CITY OF ALBUQUERQUE

March 6, 2023

Re: Hotel Zazz
3711 Central Ave. NE
30-Day Temporary Certificate of Occupancy
Transportation Development Final Inspection
Architect's Stamp dated 03-08-22 (K17-D121)
Certification dated 02-14-23

LS101

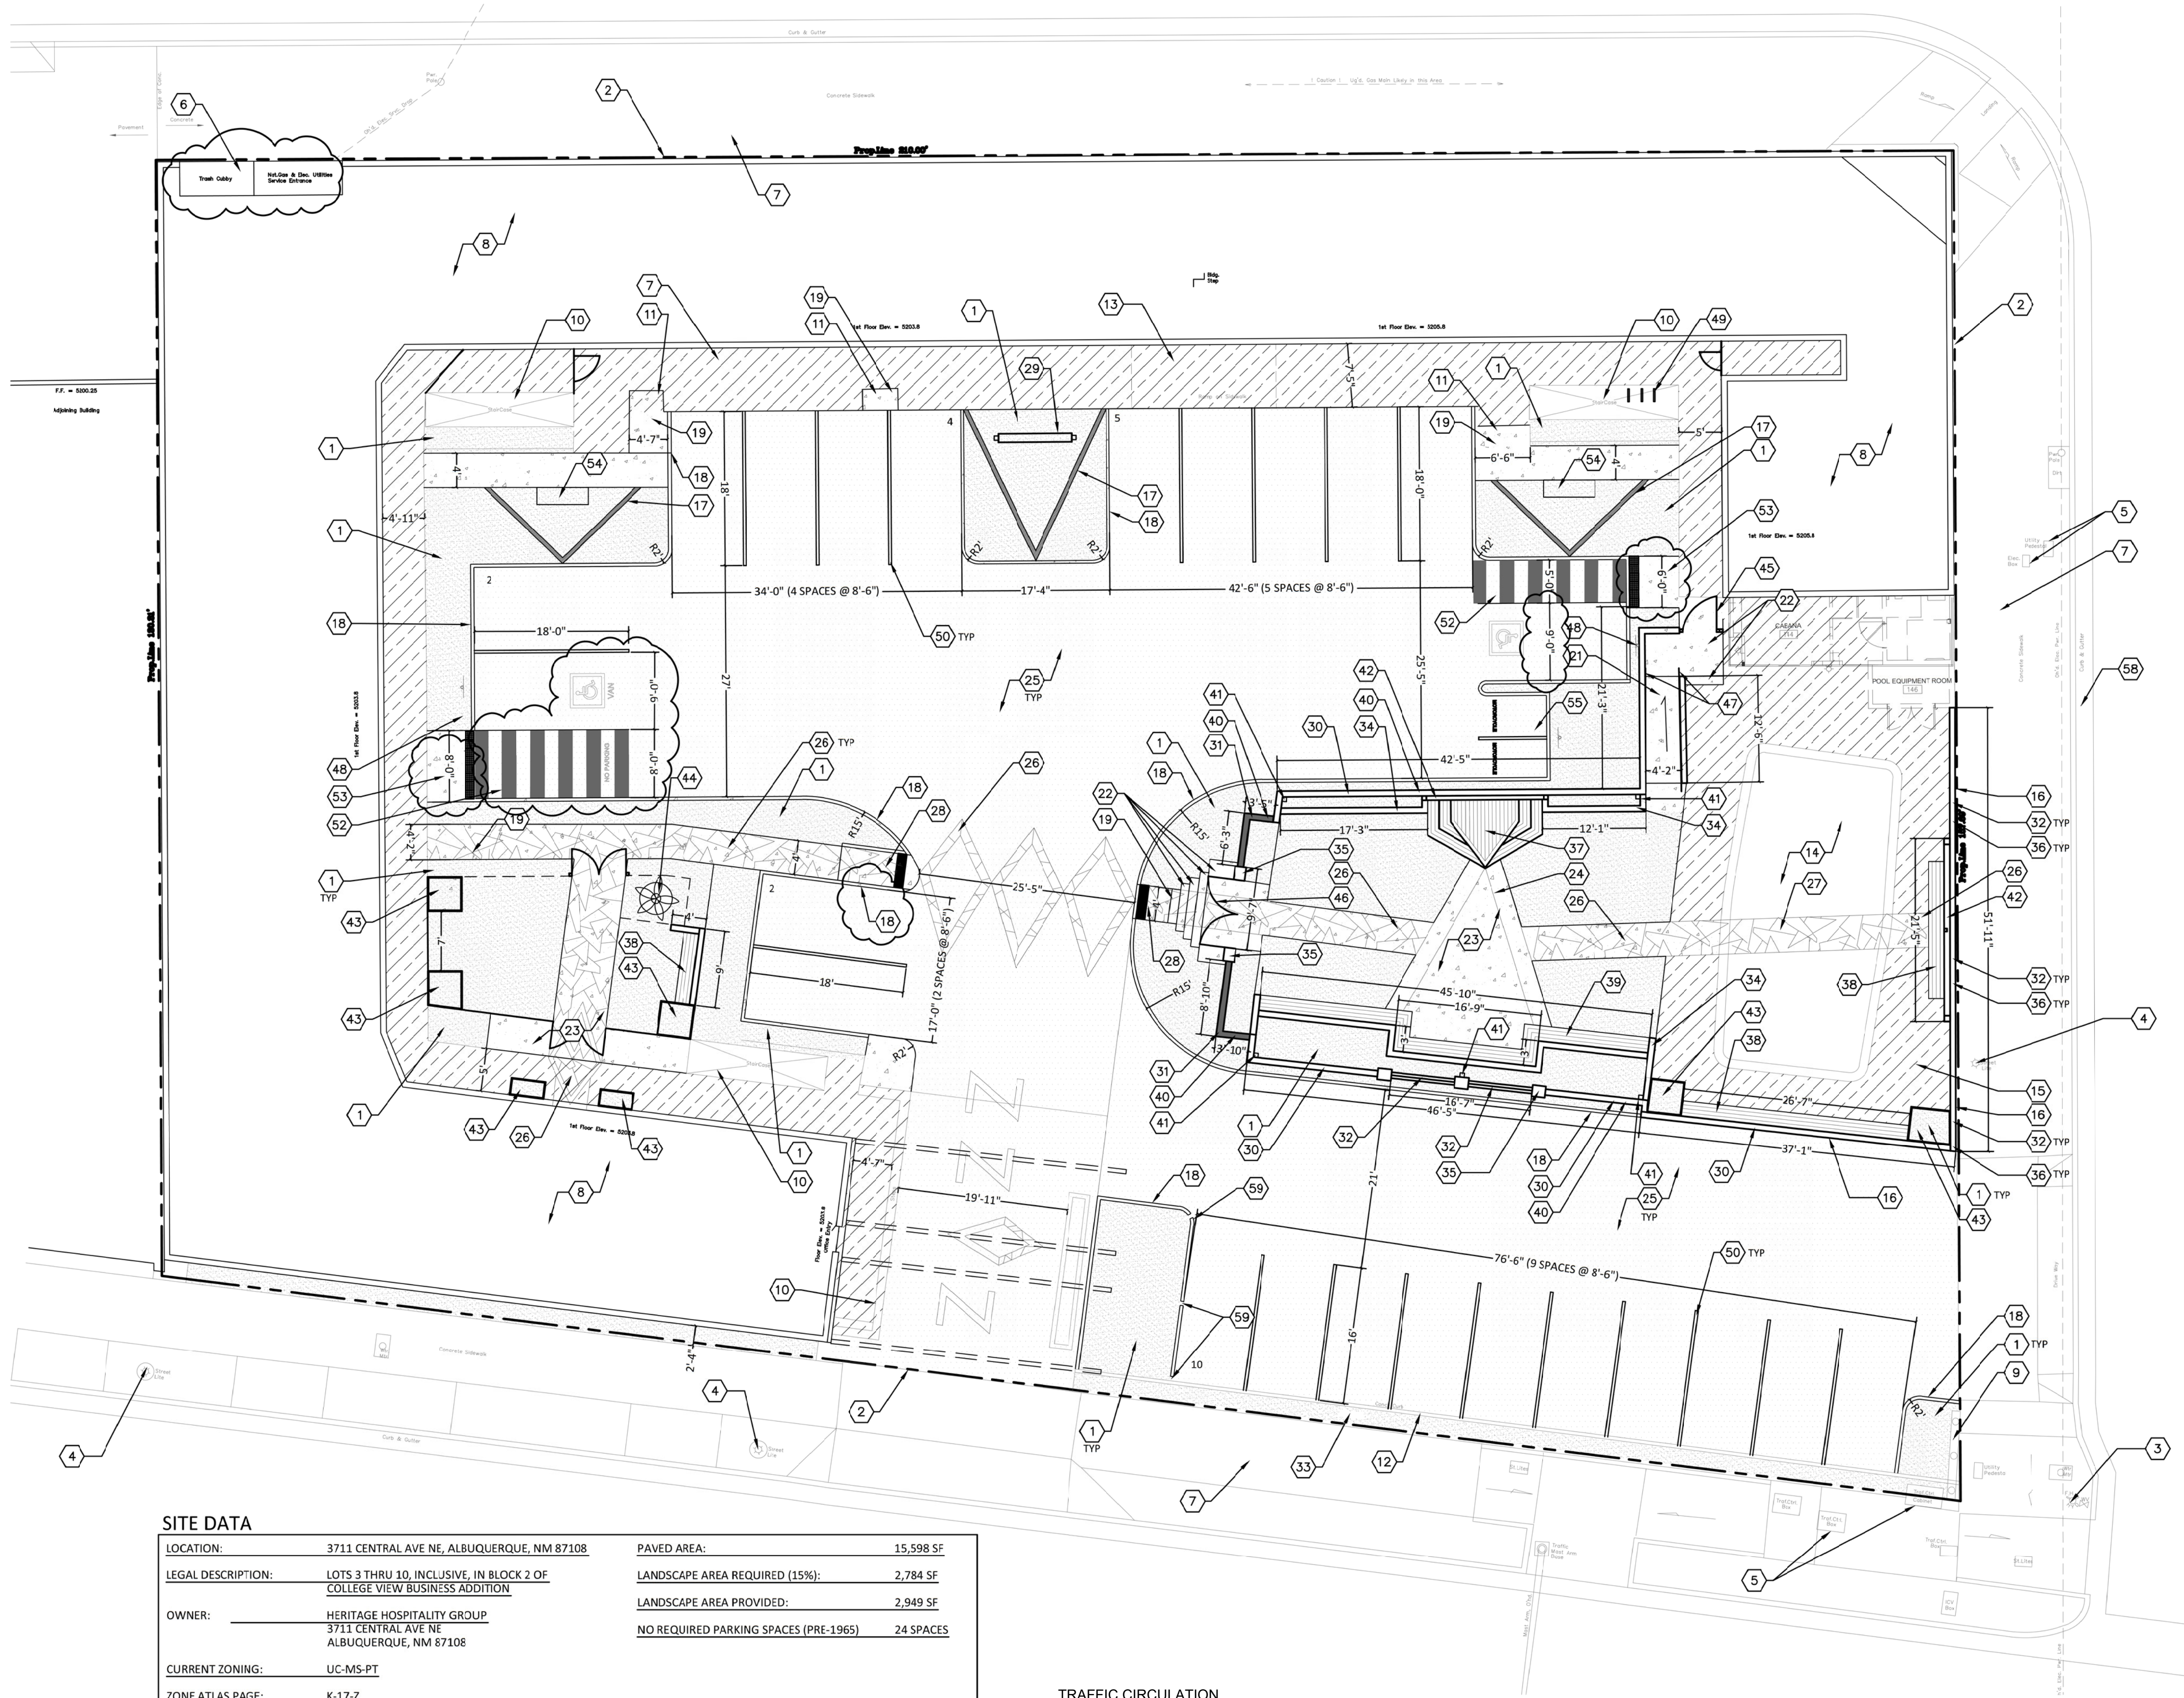
- The ADA access aisles shall have the words **"NO PARKING"** in capital letters, each of which shall be at least one foot high and at least two inches wide, placed at the rear of the parking space so as to be close to where an adjacent vehicle's rear tire would be placed. (66-1-4.1.B NMSA 1978)
- The pavement marking "MC" should be shown in the opposite direction for Motorcycles entering the parking space.
- Anchor down the Bike Racks.
- ADA ramp at the north east side of the site is too steep. Per the site visit the running slope was 9.9%. Per city requirement the maximum running slope is 8.2%. please fix this issue.
